**5ft2 STUDIO ARCHITECTS, LLC**

**RE: SUB23-003 SUB1 Review Letter; 7204 78th Ave SE, Mercer Island, WA 98040**

We have outlined below our responses to your request for information on Short Plat Submittal with Number: SUB23-003. Please let us know if you have further comments.

# TREE RETENTION PLAN

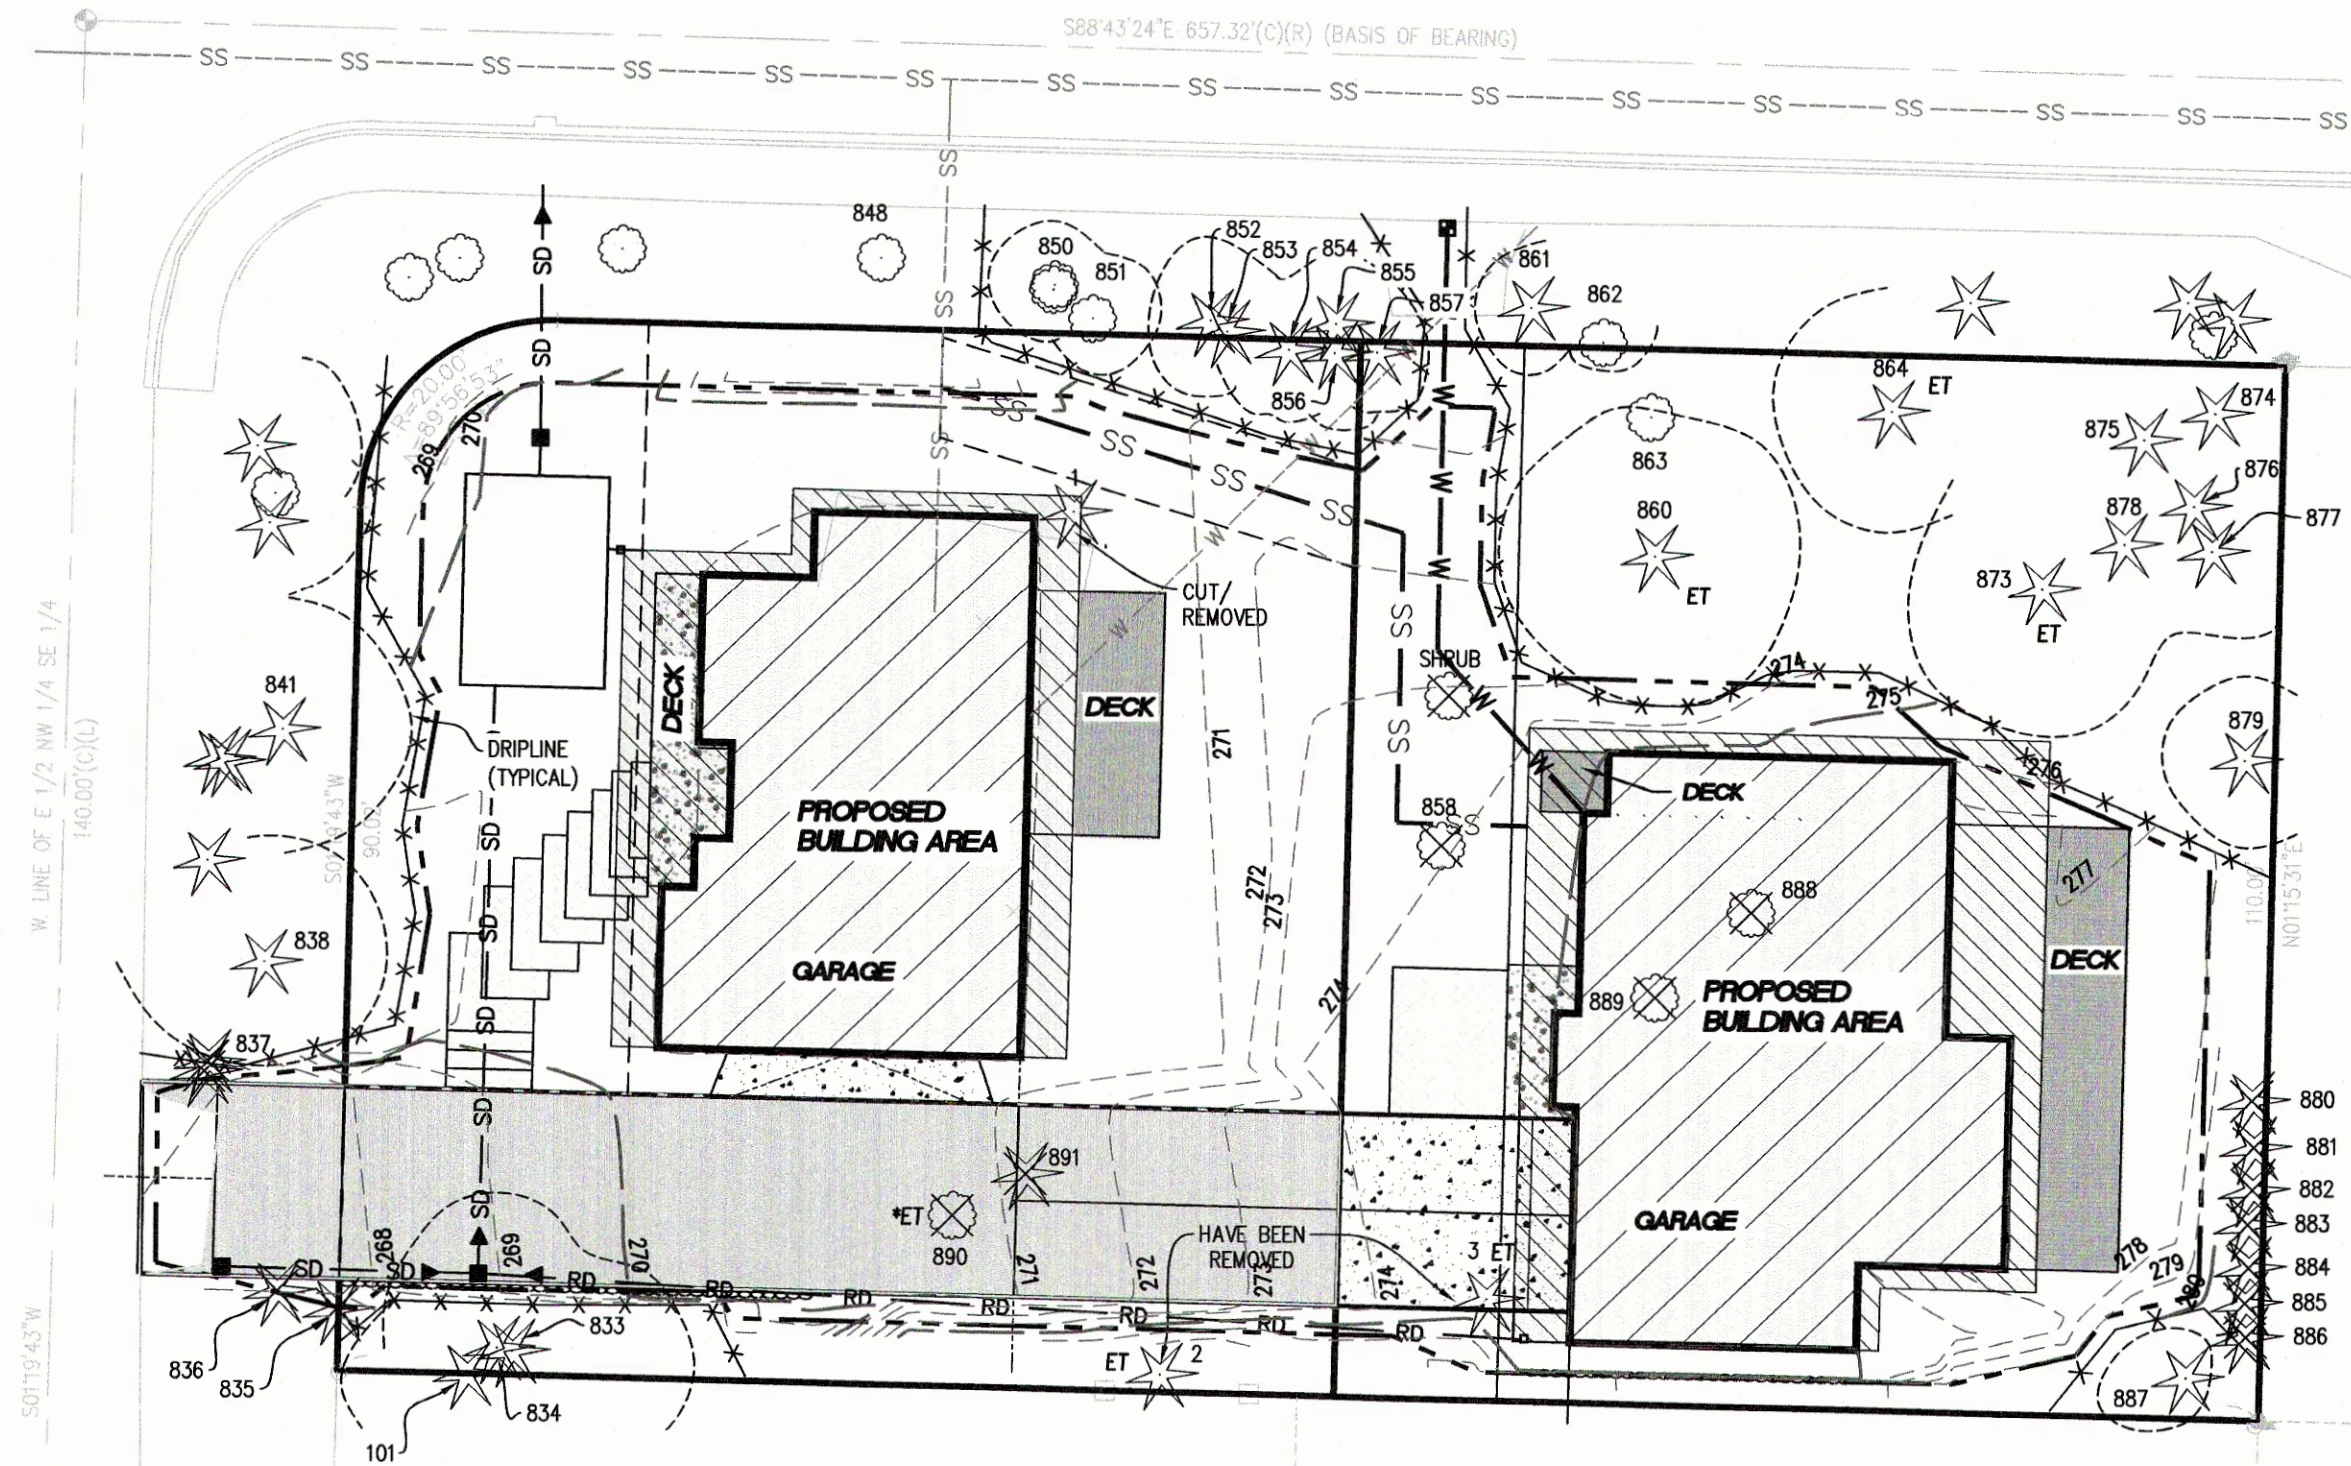
5. The clearing limits shown on sheet 7 are within tree 860's tree protection zone. Move the clearing limits outside the tree protection zone.  
[Response: clearing limits have been adjusted to avoid tree protection zone.](#)

4. Update tree inventory worksheet to exclude trees 880-886 since it is a nonregulated hedge.  
[Response: Tree inventory worksheet has been updated in the arborist report and also the drawings set.](#)
